2026 Financial Assurance Estimate Form
(with pre-plat construction)

PPR2610

Project Name: Fountain Valley School Acadmic Center

Date: March 18,2026

GESC COVER SHEET

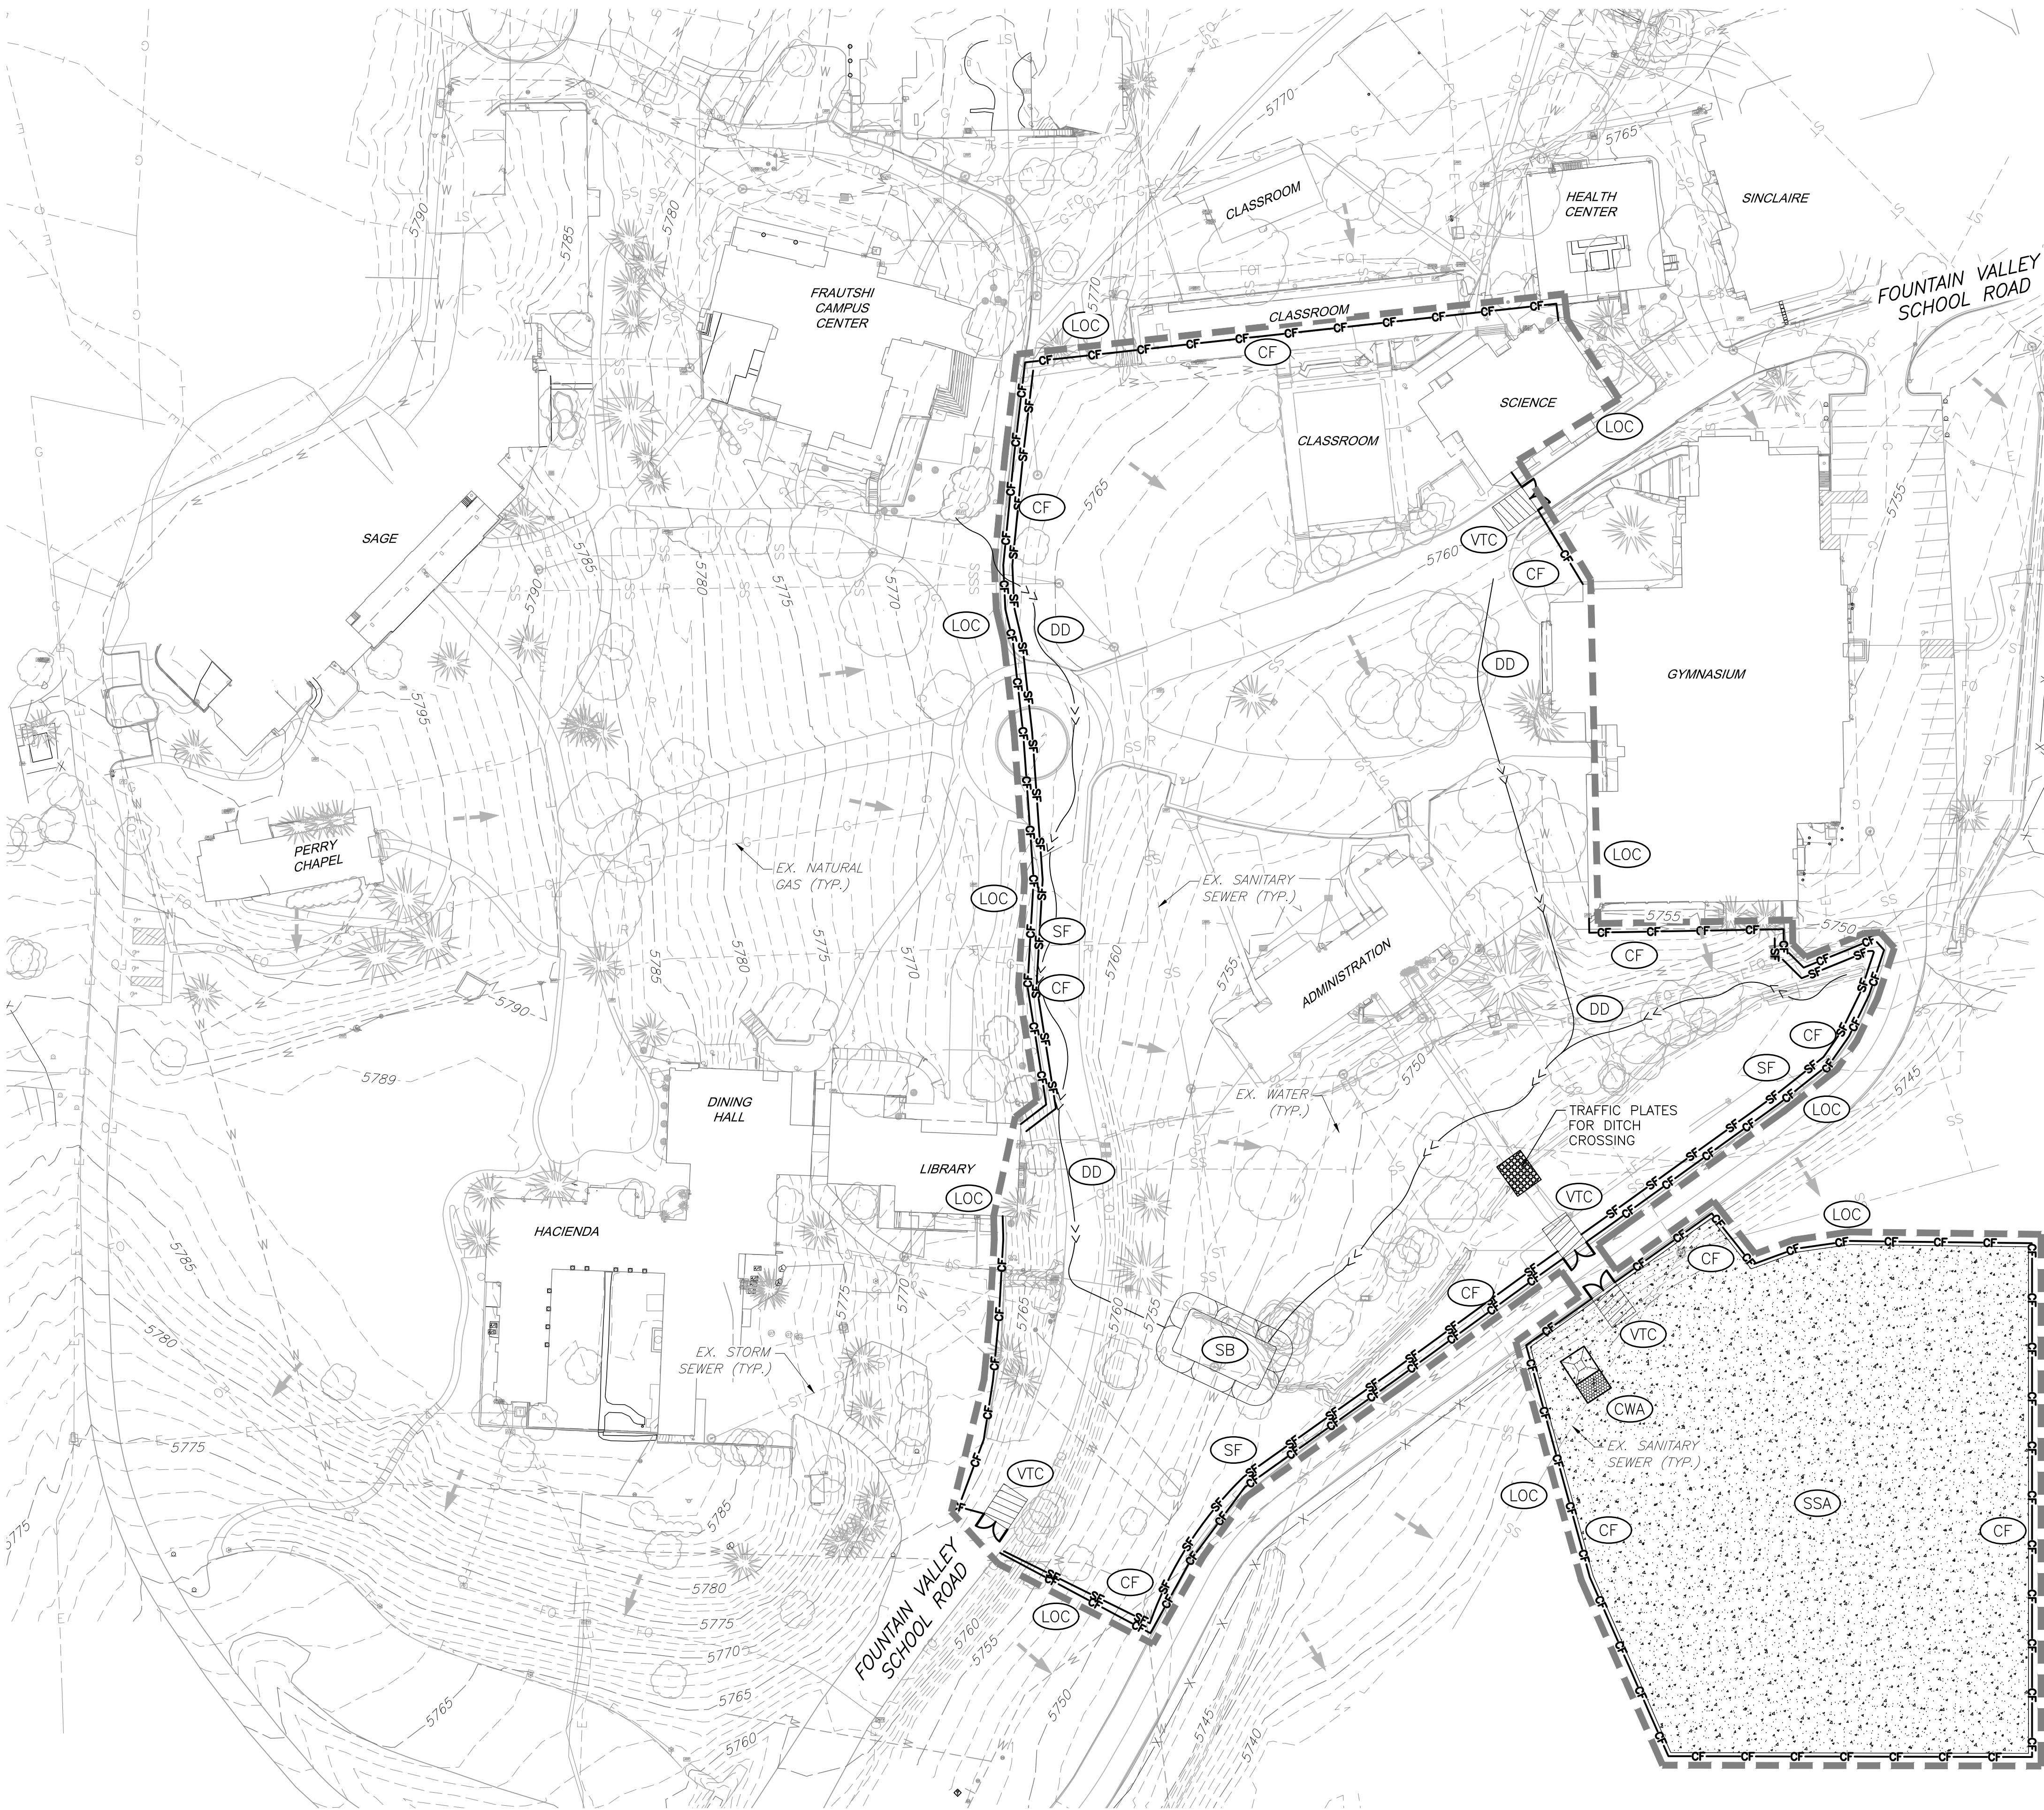
Show in GEC plans

MM Response: Check dam locations identified on GEC plans.
